CITY OF PORTLAND BUILDING PERMIT

PERMIT ID: 2012-65661

has permission to **1. interior bath renovation 2. enclose porch to create mud room (5.25' x 6.5') 3. Porch additon (6' x 18' 4 3/8") to garage/studio**

City of Portland, Maine - Building or Use Permit

**Proposed First  
Floor Plan**

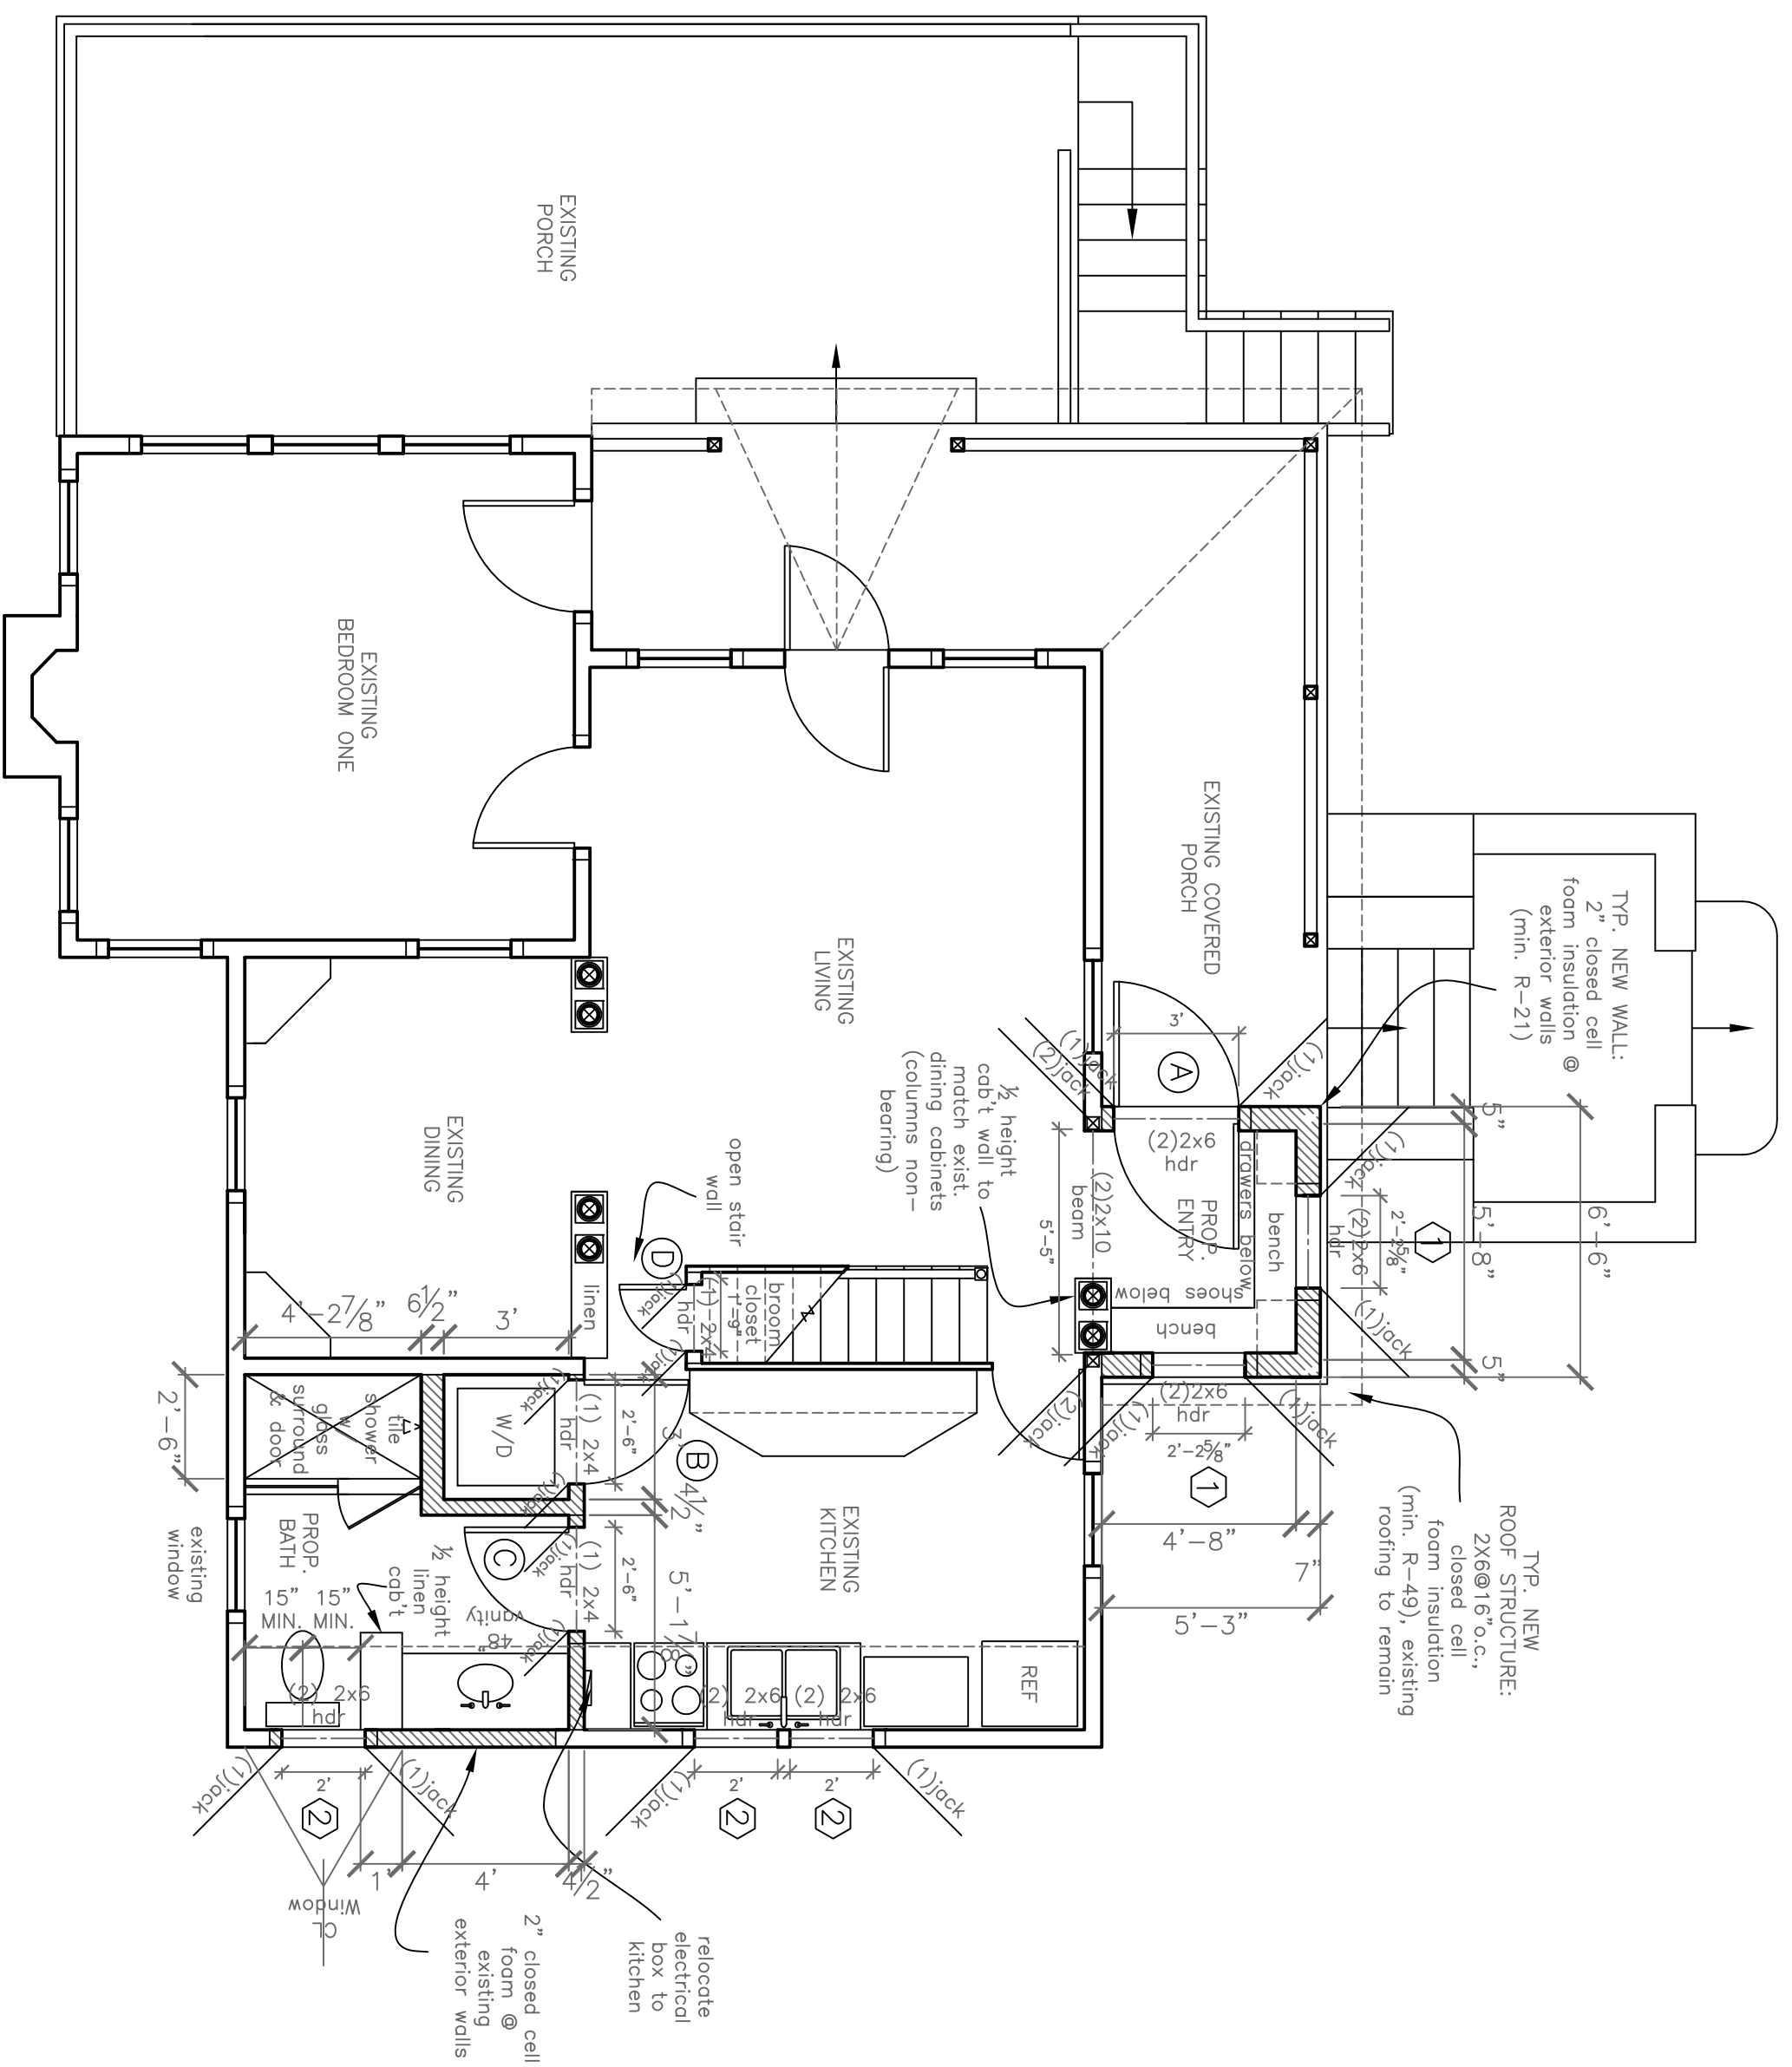
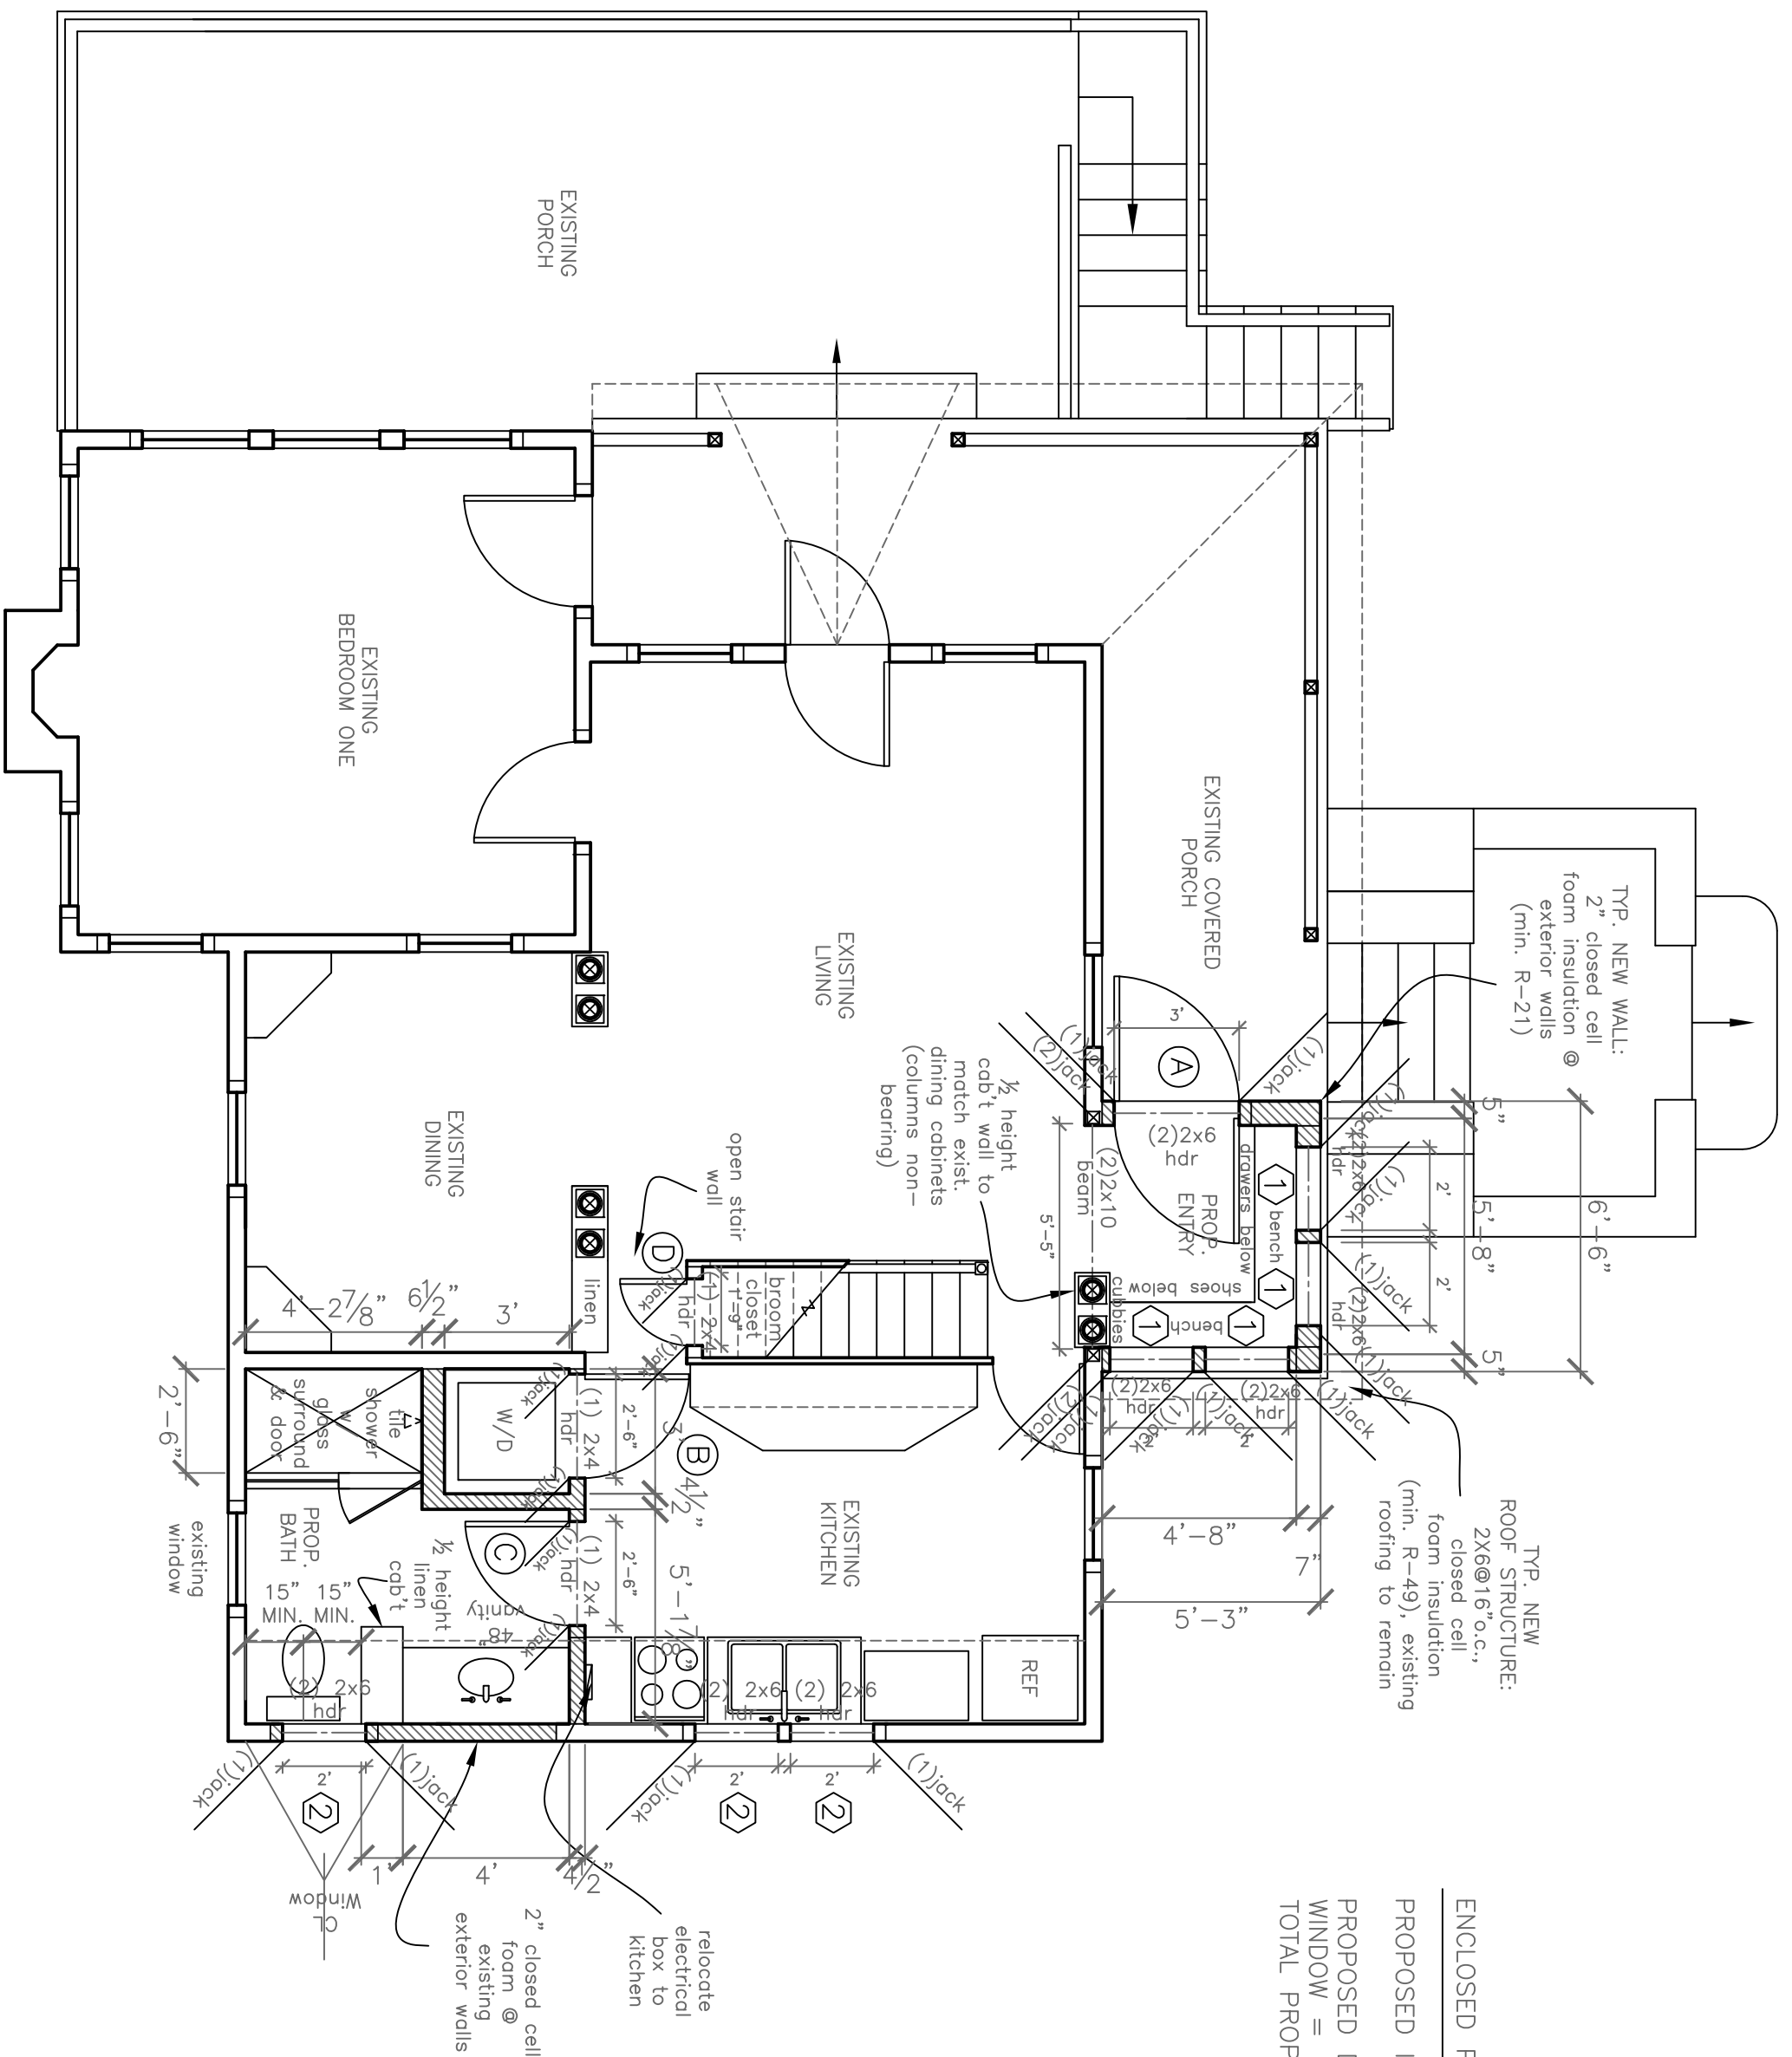
Note: Using section 14-427 to enclose part of existing covered porch. The total area of the walls is 112 sf; the square footage of the widows and door is 60 sf which is 53.6% of area that is glass. **Ok to Issue:**

I'm glad that you were aware of section 14-427. You might very well be meeting the greater than 50% requirement. I just need you to give me the figures showing what the square footage is for each wall and what the square footage is for the windows and doors.

The windows are 9.7 SQFT each and the door is 20 SQFT. The total wall area is 114 SQFT. So, I will need to add 2 more windows.
